DRB Application No.: 0700276
Project Name: Landscaping 21A TRUS
Agent: Alvin H. Hageman

Project # 1003121
Phone No.: 249.3378

14. Project # 1003121
07DRB-00276 Minor-Prelim&Final Plat
Approval

STEWART INGHAM agent(s) for ZIA TRUST INC request(s) the above action(s) for all or any portion of Tract(s) 19, M.R.G.C.D. MAP 36 (to be known as **TRACTS A & B, LANDS OF ZIA TRUST**) zoned R-1 located on FORAKER NW between LOS TOMASES NW and 8TH ST NW containing approximately 1 acre(s). [REF: 07 DRB00135] (H-14) **THE PRELIMINARY AND FINAL PLAT WAS APPROVED WITH FINAL SIGN-OFF DELEGATED TO UTILITIES DEVELOPMENT TO ADD BENEFICIARY AND MAINTENANCE LANGUAGE FOR PRIVATE WATER AND SEWER SERVICE LINES AND ACCESS EASEMENT AND TO PLANNING FOR AGIS DXF FILE AND TO RECORD.**

**BOUNDARY SURVEY
OF
TRACT 19
M.R.G.C.D. MAP No. 36
WITHIN
SECTION 8, TOWNSHIP 10 NORTH, RANGE 3 EAST
CITY OF ALBUQUERQUE
BERNALILLO COUNTY, NEW MEXICO
OCTOBER, 2003**

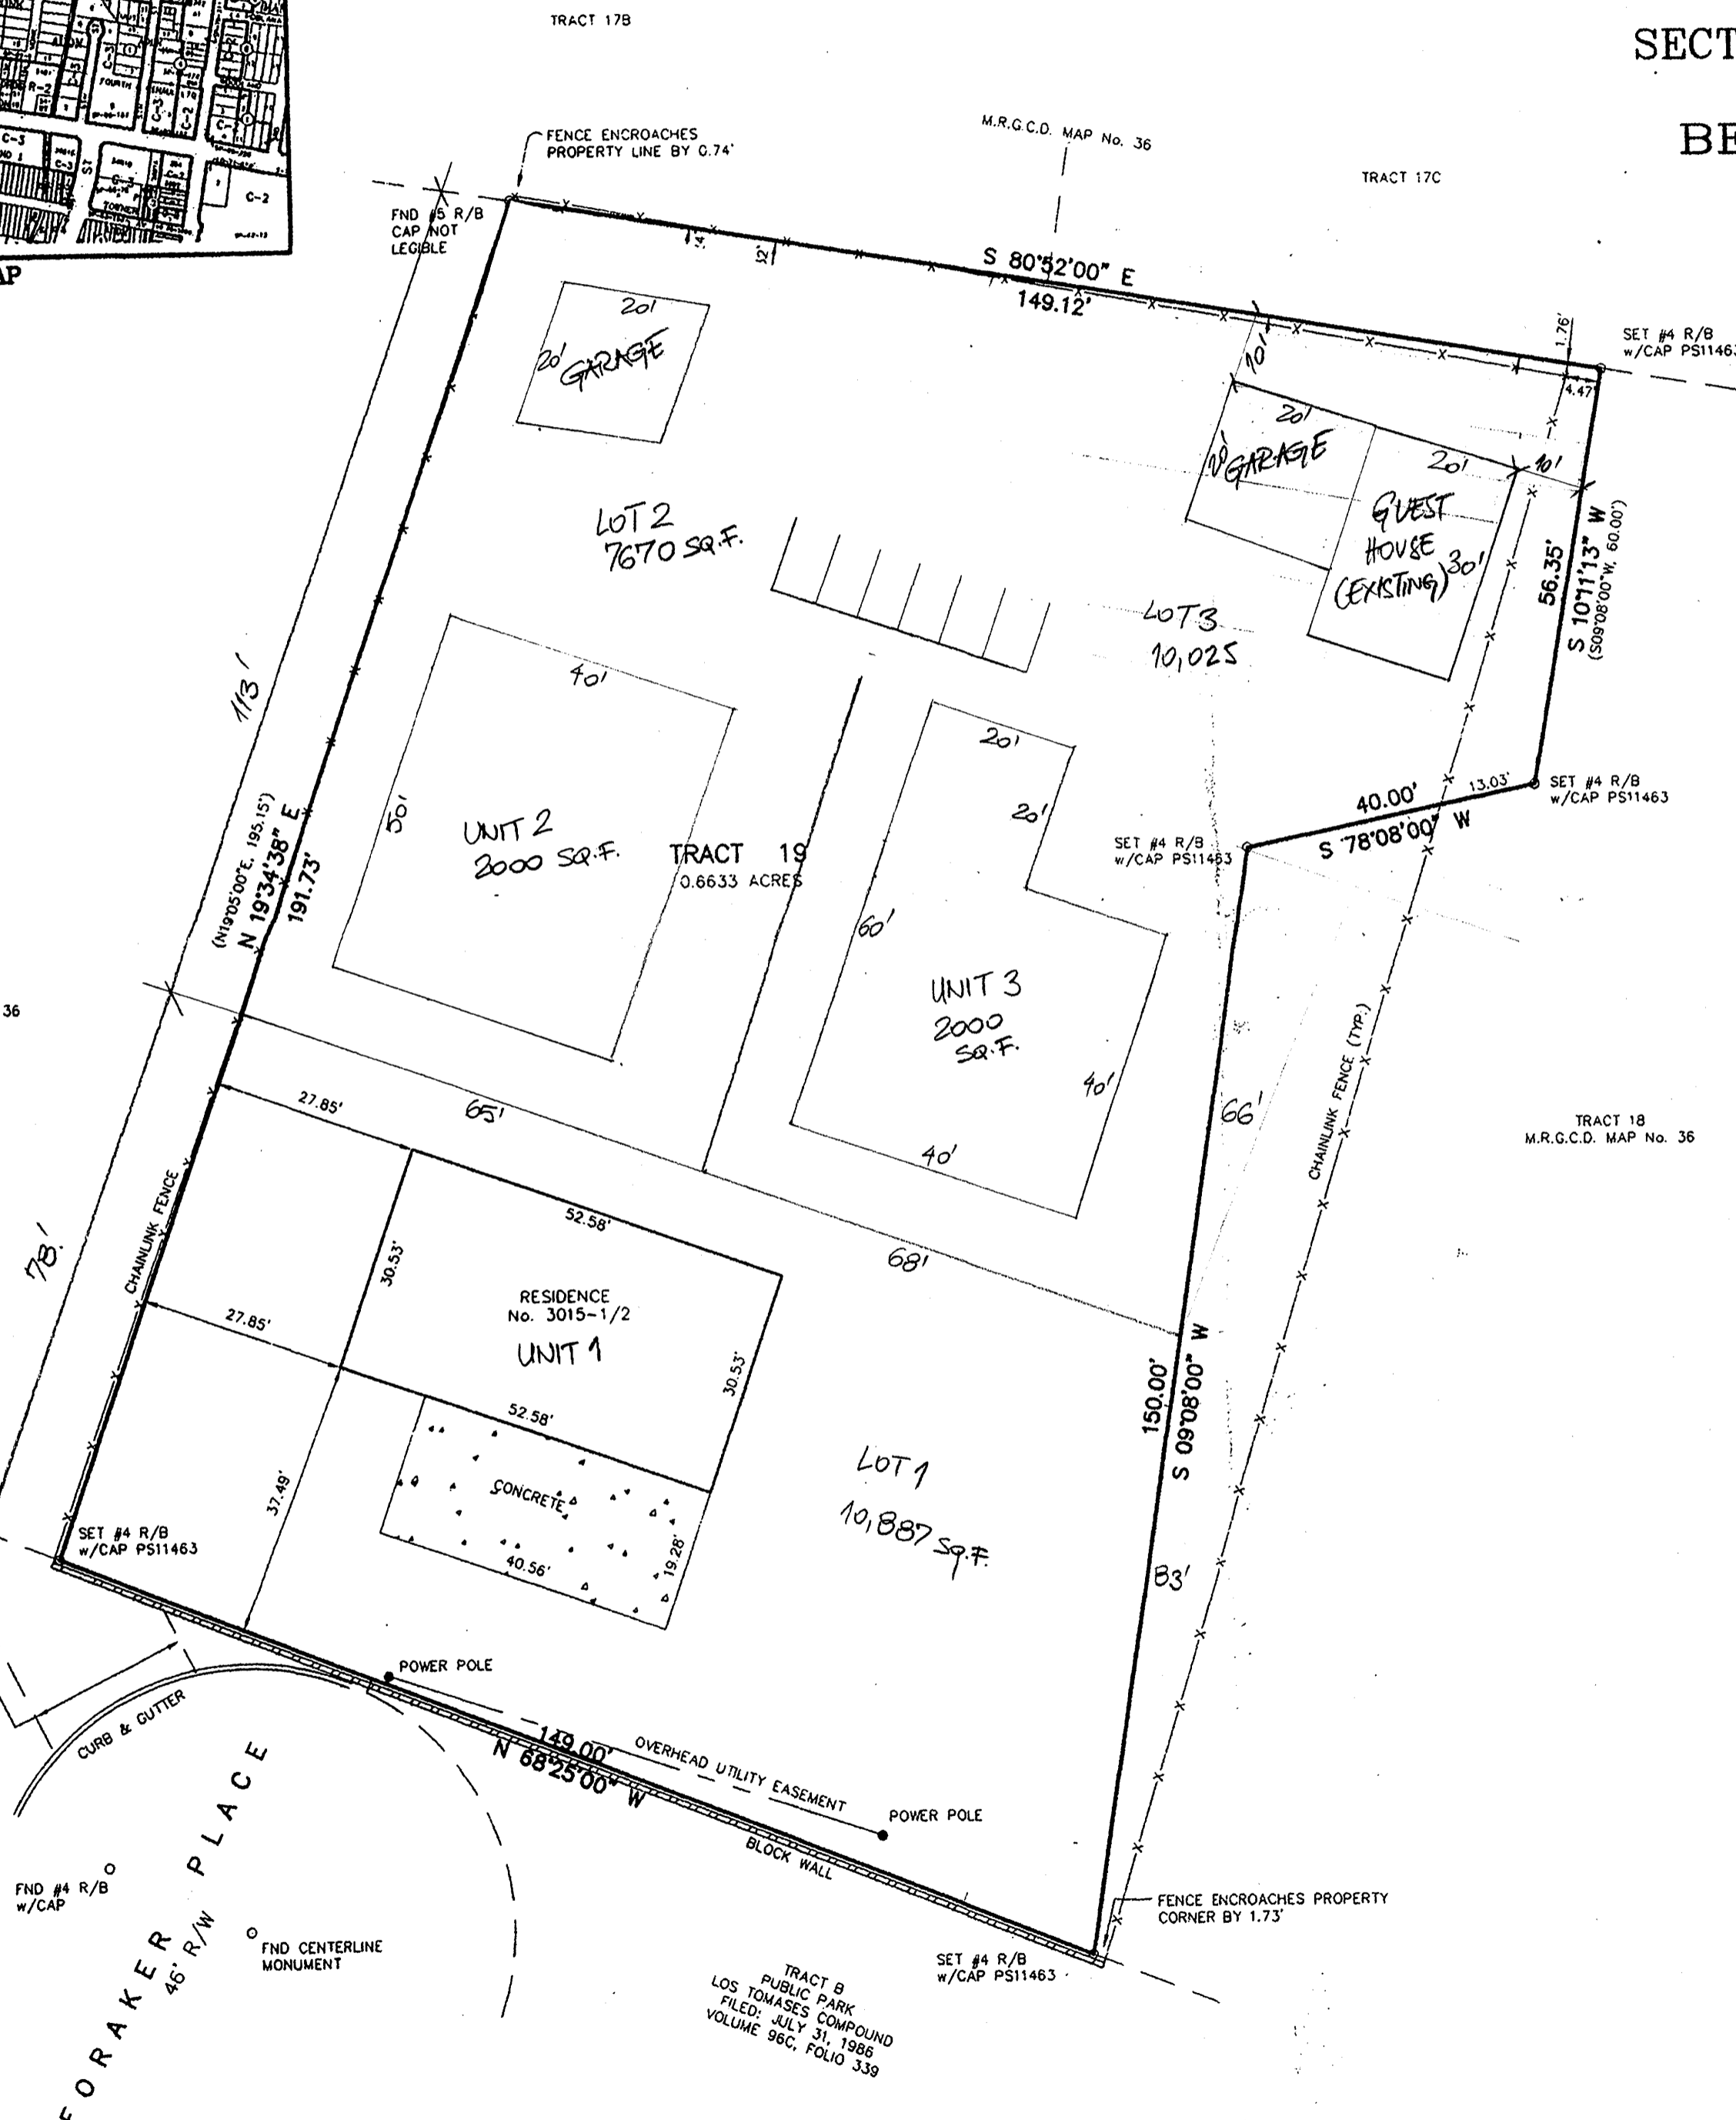
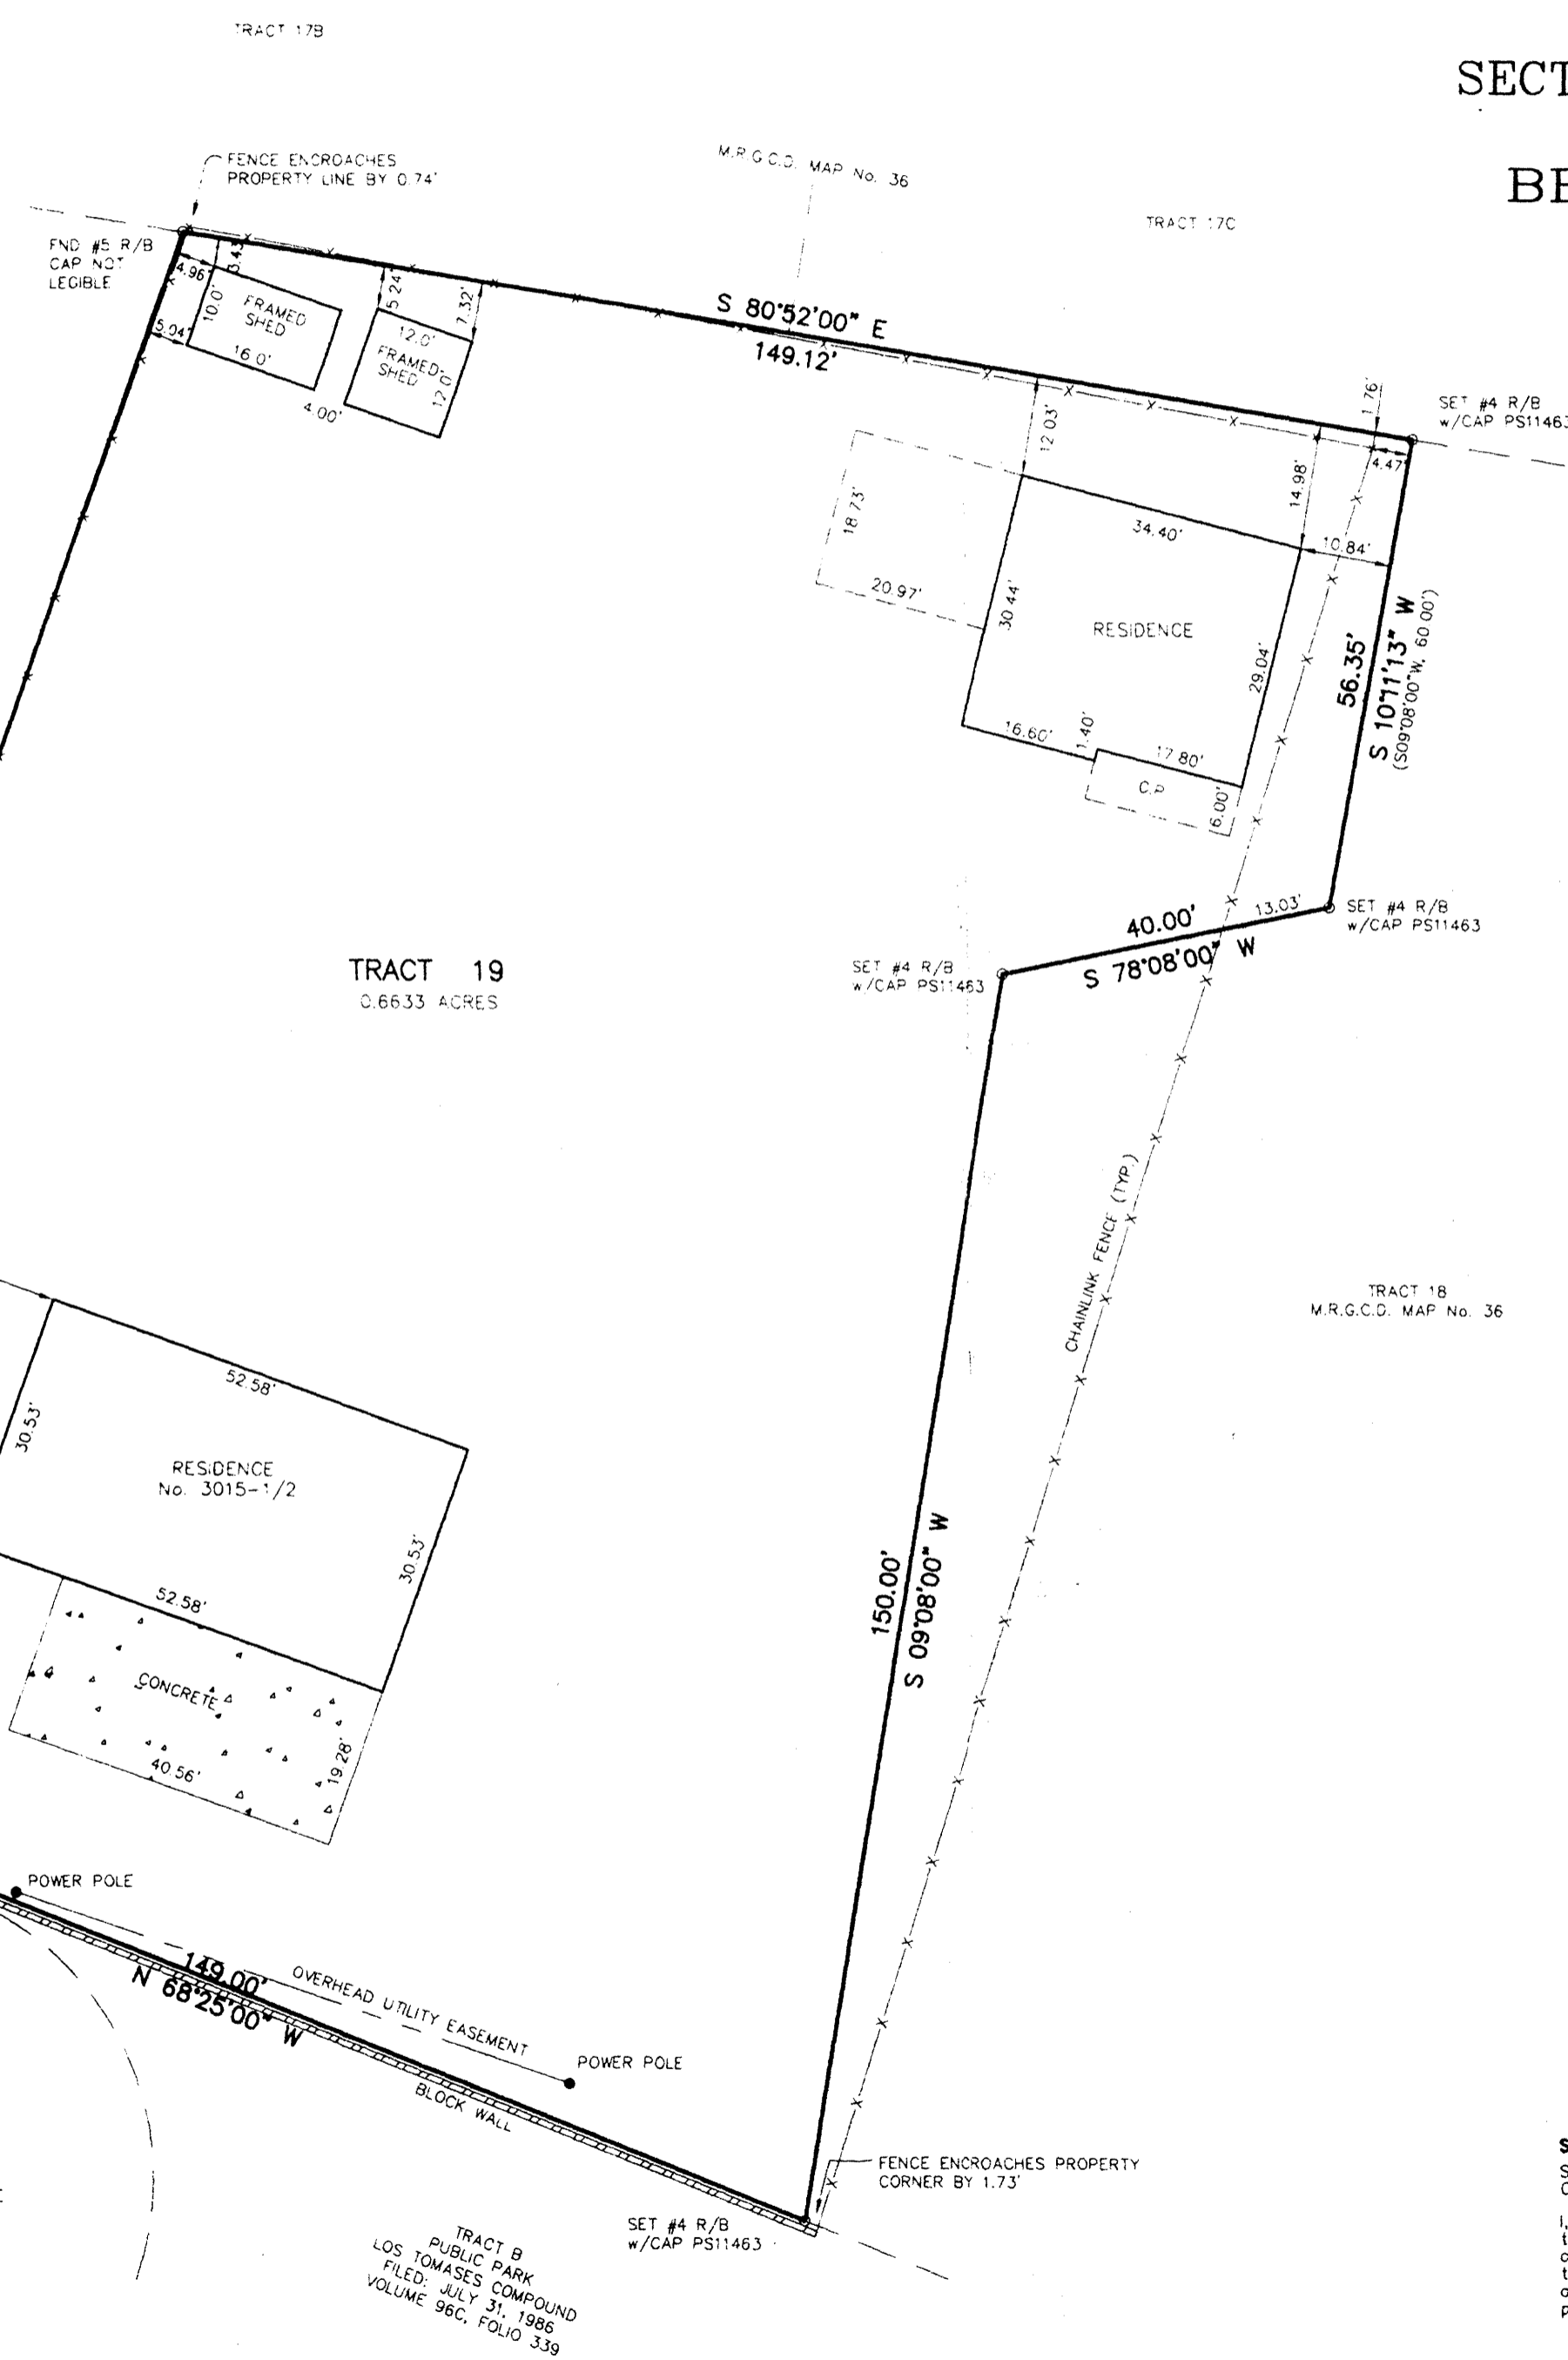
Only one residence is allowed per lot in R-1 Zoning.

Be sure to follow the required R-1 setbacks.

It's unclear where the lot lines are.

Need cross-lot drainage easements.

No.	Comment
(1)	NEED TO SHOW ADJOINING LOTS THAT HAVE ACCESS TO EASEMENT FROM LOS TOMASES DR. - NEED TO SHOW THIS EASEMENT & WIDTH
(2)	CROSS ACCESS EASEMENT WILL BE NEEDED BETWEEN LOTS 2 & 3
(3)	DUE LOT 1 TAKE ACCESS USING THE 22' PRIVATE EASEMENT?
